**Subject:** LAND OFF THORNHILL ROAD, DEWSBURY, WF12 9QE - 2023/62/90209/E

**LAND OFF THORNHILL ROAD, DEWSBURY, WF12 9QE**  
**ERECTION OF DETACHED DWELLING AND TWO-STOREY WORKSHOPS**  
**(2023/62/90209/E)**

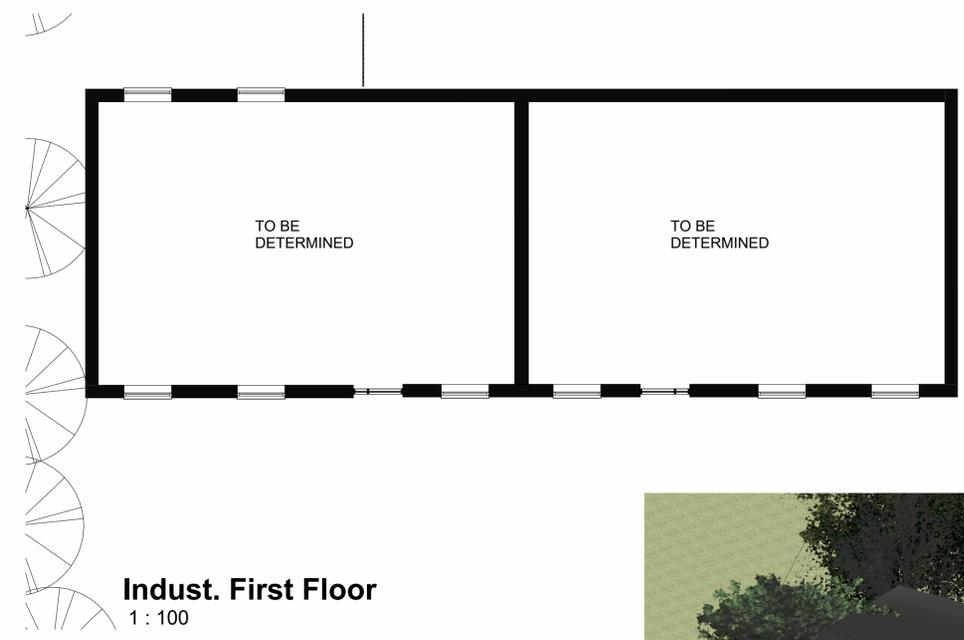
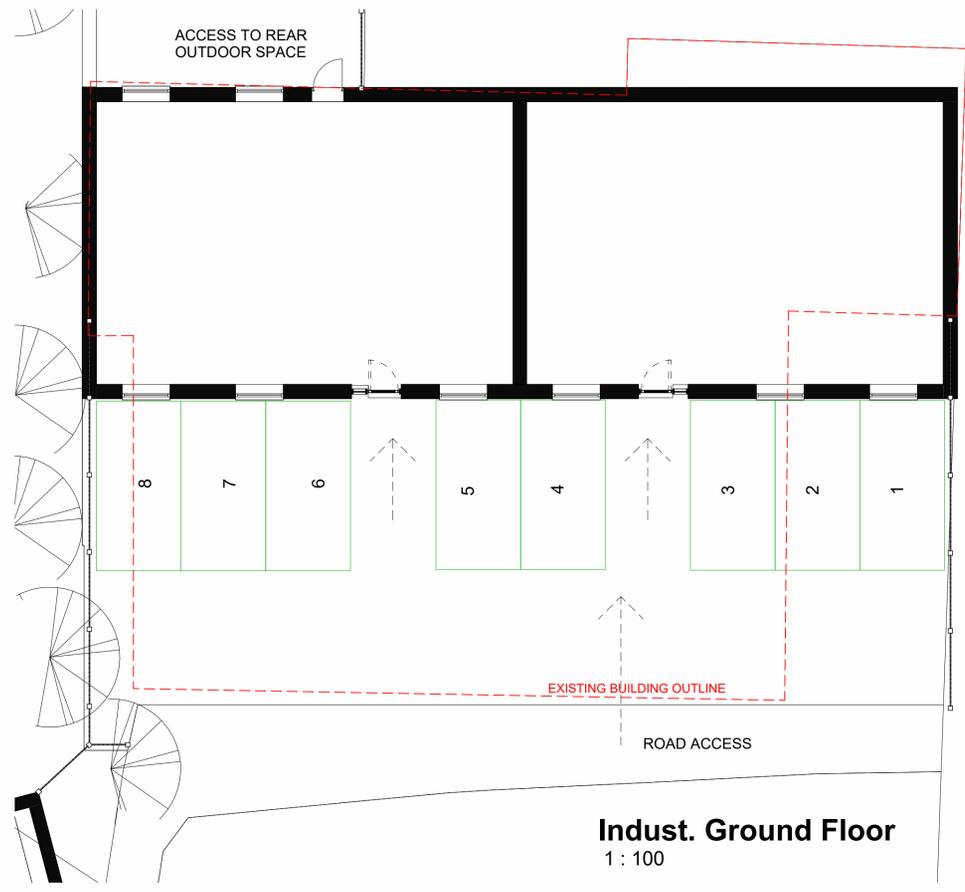
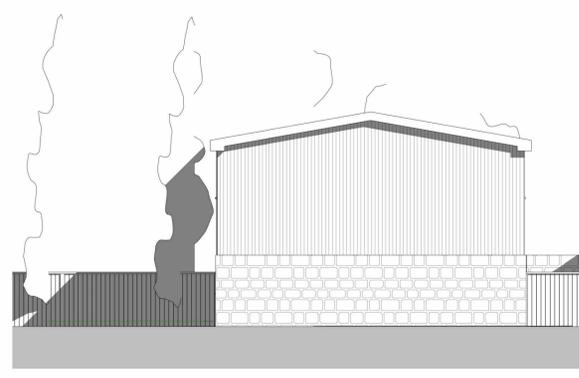
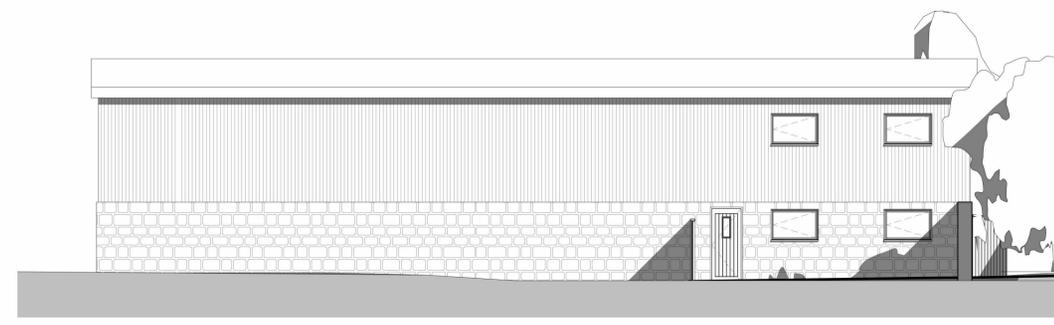
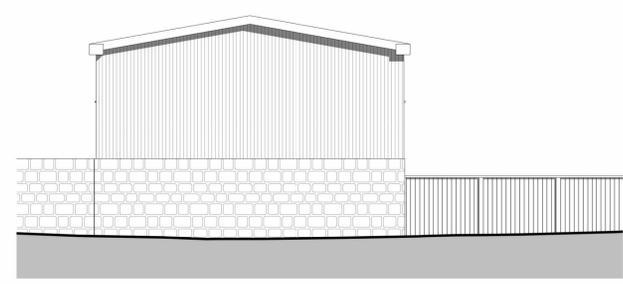
In respect of the 2 new business units, this element of the proposal is, in principle, compliant with **Policy LP8**. However, we have concerns that the design of this part of the scheme is contrived and this is likely to adversely affect its attractiveness for business use. Issues include the small size and dimensions of the units; the size of the parking areas, which only appear suitable for the private car; the lack of unloading and manoeuvring space for larger commercial vehicles<sup>2</sup>; and the absence of roller shutter doors on either of the business units.

The proximity of the new business units to the proposed new dwelling also has to be considered from a residential amenity point of view. Whereas there are presently no residential amenity constraints on the operation of the existing businesses at the site (consistent with the designation of the site as a Priority Employment Area), there will be a need to consider the relationship between the new business uses and the proposed new dwelling. It is likely that the Council will need to restrict the hours of operation of the new business units, and potentially impose noise controls, therefore reducing their overall attractiveness to occupiers.

Regarding the proposed dwelling, this is of a substantial size (3,190 sq.ft) and would occupy approximately 75% of the total area of the application site, which demonstrates that the great majority of the redeveloped site would be for non-employment use. In such circumstances, **Policy LP8** requires demonstration that this part of the site is no longer capable of employment use. However, this application fails that test for two important reasons.

In the light of the above, we consider that this is a sensitive site from a flood risk point of view. Furthermore, the inclusion of part of the site within Zone 3ai means that there should be no increase in development footprint in this specific area. In this context it can be seen that the Zone 3ai area (dark blue shading on **Figure 1** above) is currently located where the open yard of \_\_\_\_\_ is situated, but the proposals seek to provide the new dwelling in this area.

There would be a substantial increase in built footprint in the very part of the site where there should be no increase in footprint, and these proposals therefore have the potential to increase flood risk elsewhere contrary to **Policy LP27** of the Local Plan. Furthermore, the new dwelling would be a more vulnerable use (as defined by the Flood Risk Vulnerability Classification) in the most vulnerable part of the site from a flood risk point of view.

- The design, scale and massing of the proposed dwelling does not appear to be based on an appreciation or assessment of local building character or style. This is contrary to Local Plan **Policy LP24 Design**, which states that '*Proposals should promote good design by ensuring: a. the form, scale, layout and details of all development respects and enhances the character of the townscape, heritage assets and landscape.*
